Item No.	Report of the Head of Development Management and Building Control	
Address:	26 WINDSOR AVENUE HILLINGDON	
Development:	Part single; part two-storey rear extension to the host dwelling (following demolition of rear extension); part single part two-storey side/rear extension to form an attached new dwelling (following demolition of side extension); raising of overall ridge height; removal of front gable to host dwelling; sub-division of site; hard and soft landscaping; boundary treatment; new vehicular crossover including alterations to the existing parking provision and refuse/cycle storage (amended description)	
LBH Ref Nos:	75963/APP/2024/1397

Drawing Nos:	20/028_S1 20/028_P1 20/028_P3 20/028_S0 20/028_P2 20/028_P1 20/028_S3 20/010_P4 20/028_P0 20/028_P0L 20/028_S1 20/028_S2 20/028_S4 20/028_S5	
Date Plans received:	24-05-24	Date(s) of Amendments(s):
Date Application valid	24-05-24

Scale: 1:100 @ A3 FEB 2025 Dwg. 20/028_P0

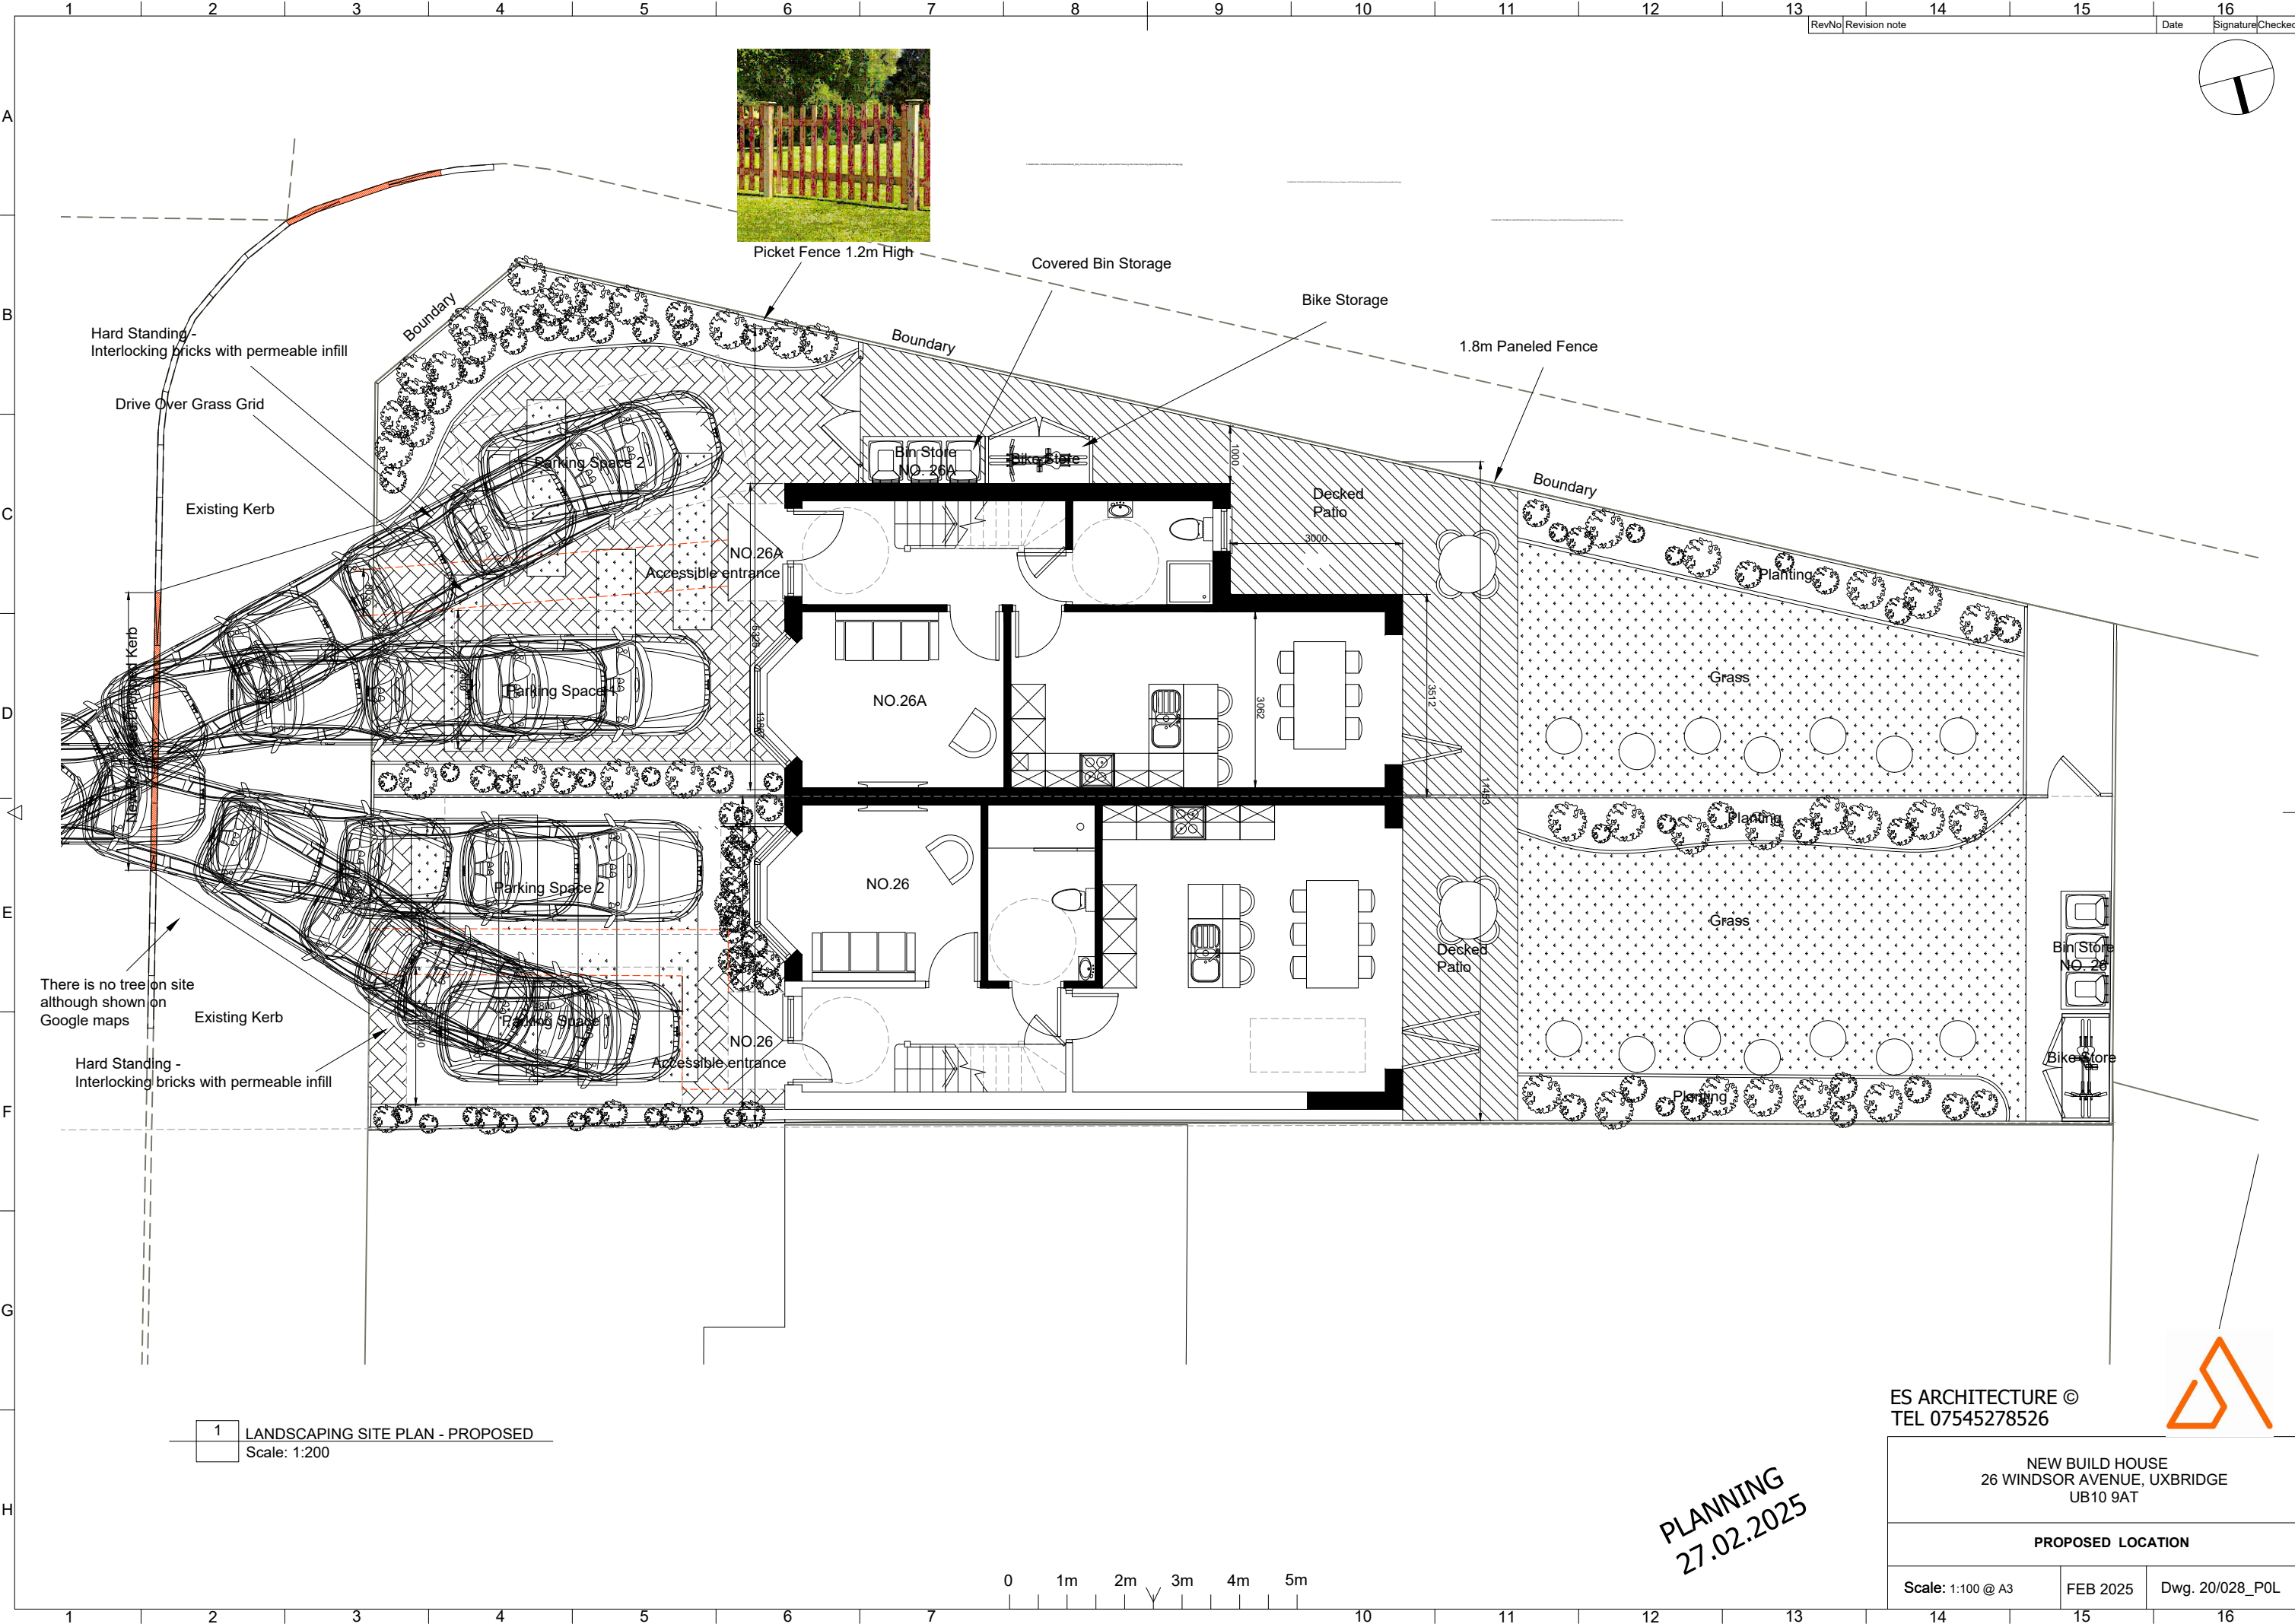
The Highway Authority is concerned that the application is invalid as the red line and blue line of the application site have been drawn incorrectly as shown in Drawing 20/028_P0 titled Proposed Location.

Drawing 20/028_P0 titled Proposed Location shows the new dwelling outlined in blue and the existing dwelling in red. This should be amended to both be outlined in red.

1 GROUND FLOOR PLAN - PROPOSED
Scale: 1:100

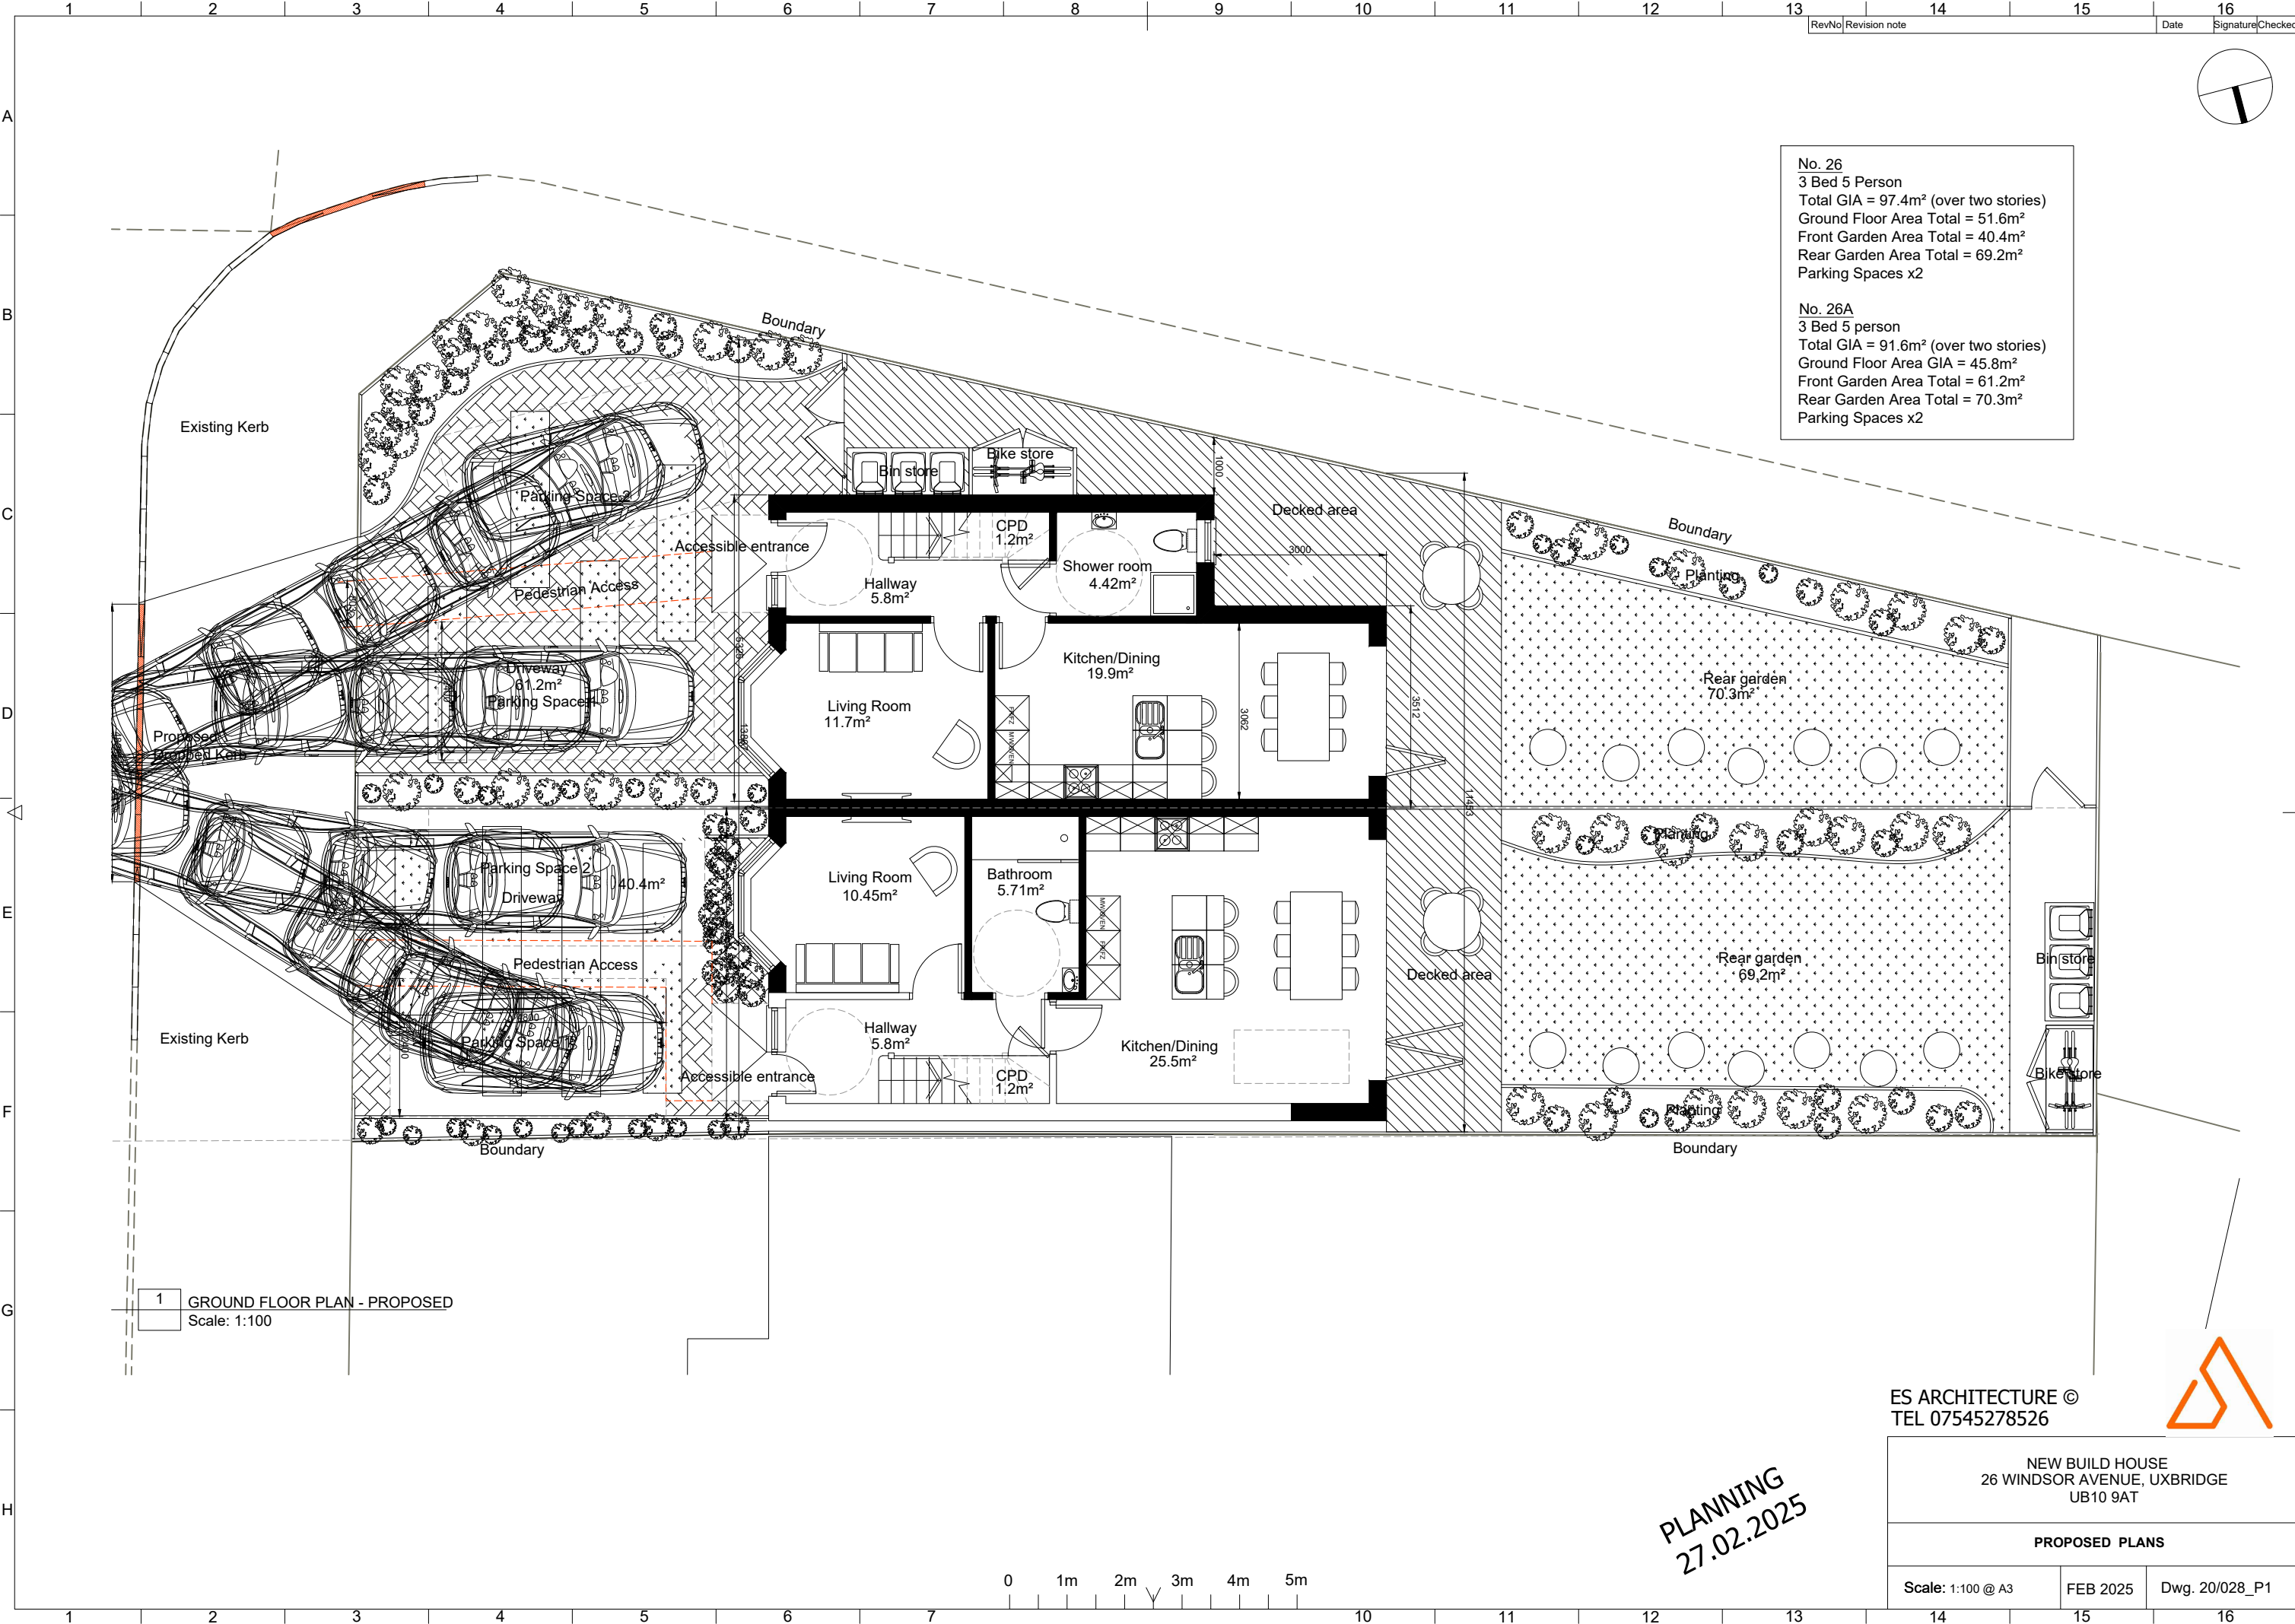
The proposed dwellings would be classed as 3 bed 5 person dwellings given the size of the bedrooms. Policy D6 of the London Plan (2021) requires that 3 bedroom properties with an occupancy level of 5 should have a minimum GIA of 93sqm with 2.5sqm of built in storage. The dwelling at no.26 would have a GIA of approx. 97sqm which would meet this requirement. However, the new dwelling (no.26A) would have a GIA of approx. 91sqm which is under the required amount which would leave future occupiers to have a poor level of internal living accommodation to the detriment of their amenities.

FRONT ELEVATION - PROPOSED

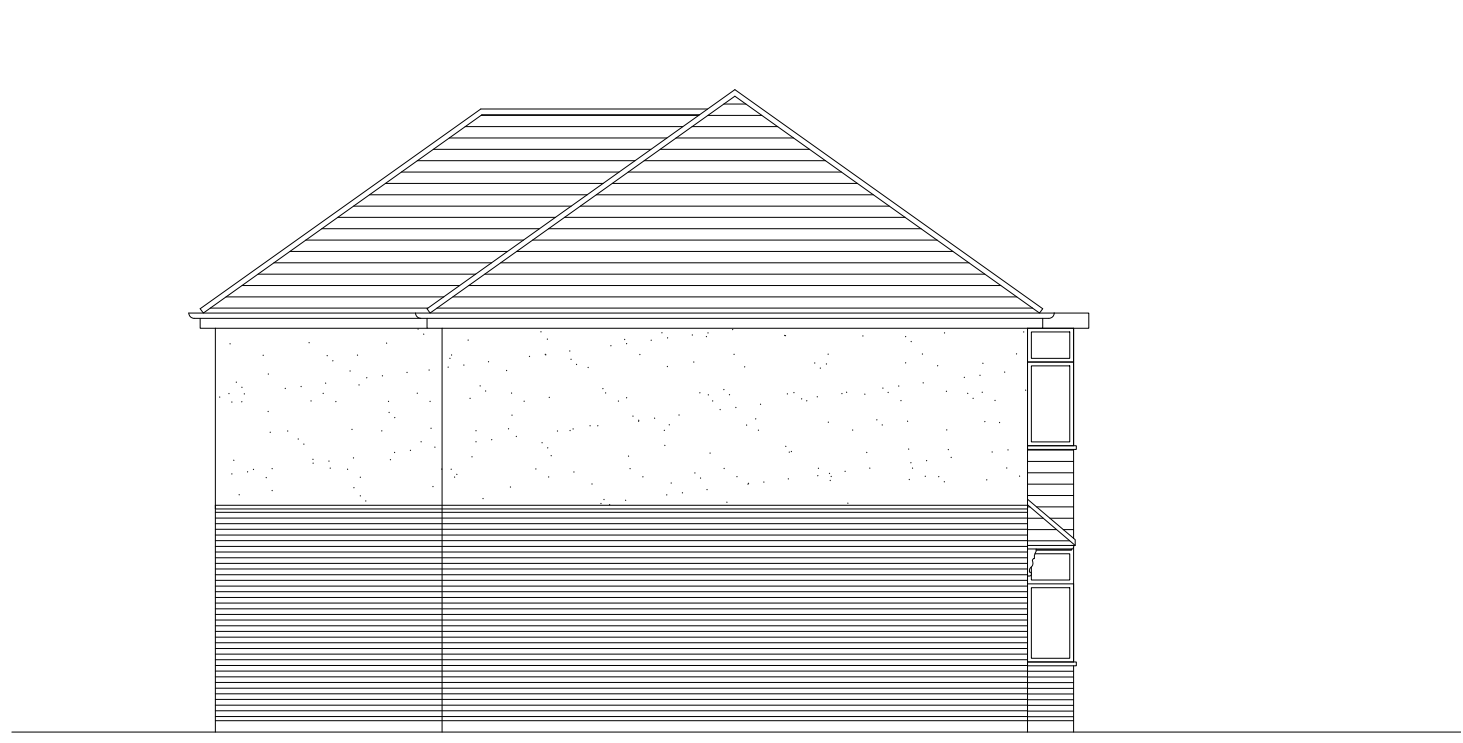
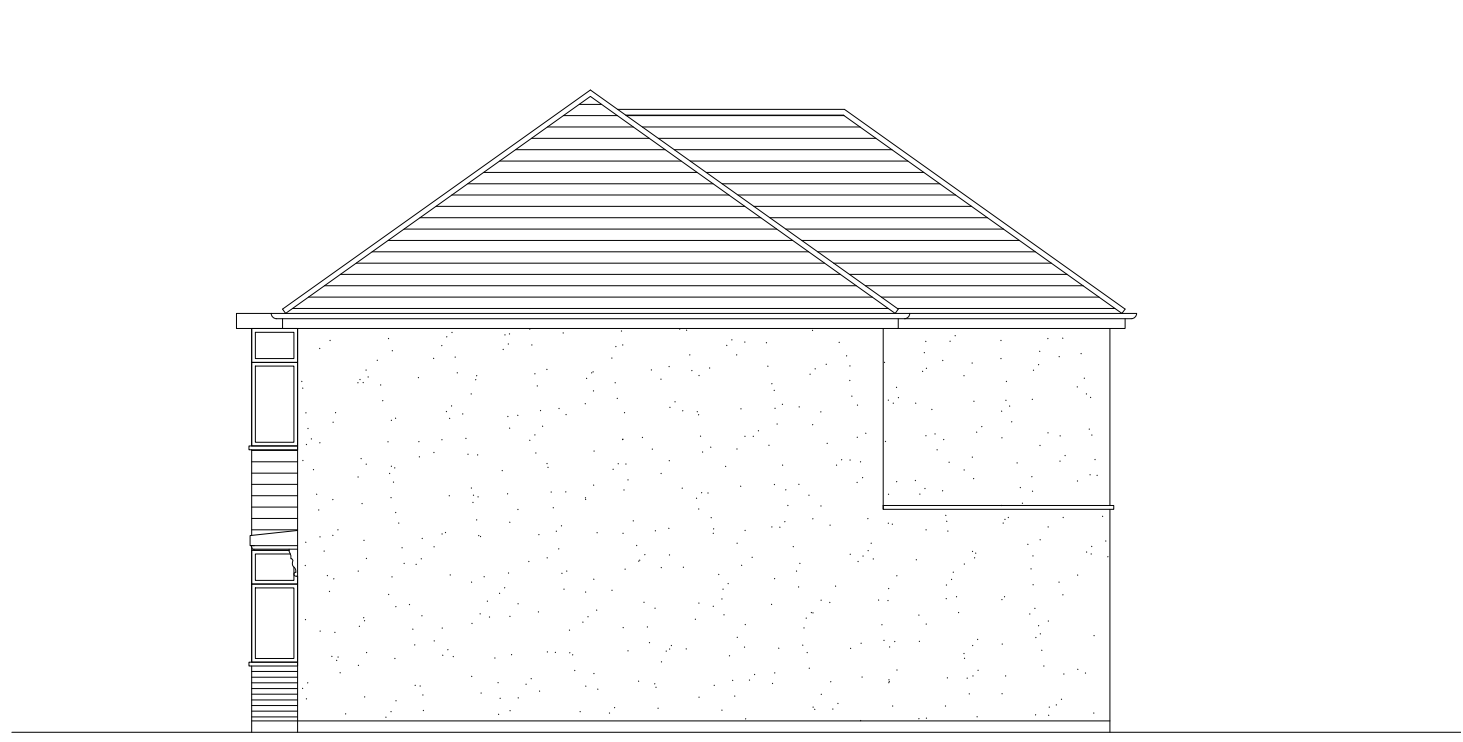
As noted within the previous case officers report 'In order to accommodate the proposed semi-detached pair, the host dwelling would have to lose its characteristic front gabled feature (noting no.28 does not have this) and be reduced in width by approx. 0.7m. This would result in the host and proposed dwelling appearing overly narrow and elongated when viewed in isolation with the properties along this part of Windsor Avenue and especially the subject corner plots of reference - no.2, 28, 50 and also no.48 and 70 of which have historically constructed extensions to form new attached dwellings. This lack of proportion would be exacerbated by the raising of the roof ridge. The works undertaken to the host dwelling as an initial stage of the proposal would detriment the form, proportions and appearance of the dwelling as viewed within the street scene'.

by approx. 0.5m. A street scene elevation drawing has not been provided to show how the development would integrate with the surrounding properties. As such, it cannot be concluded what impact this would have on the surrounding area. Any future application should be accompanied with existing and proposed street scene elevation drawings.
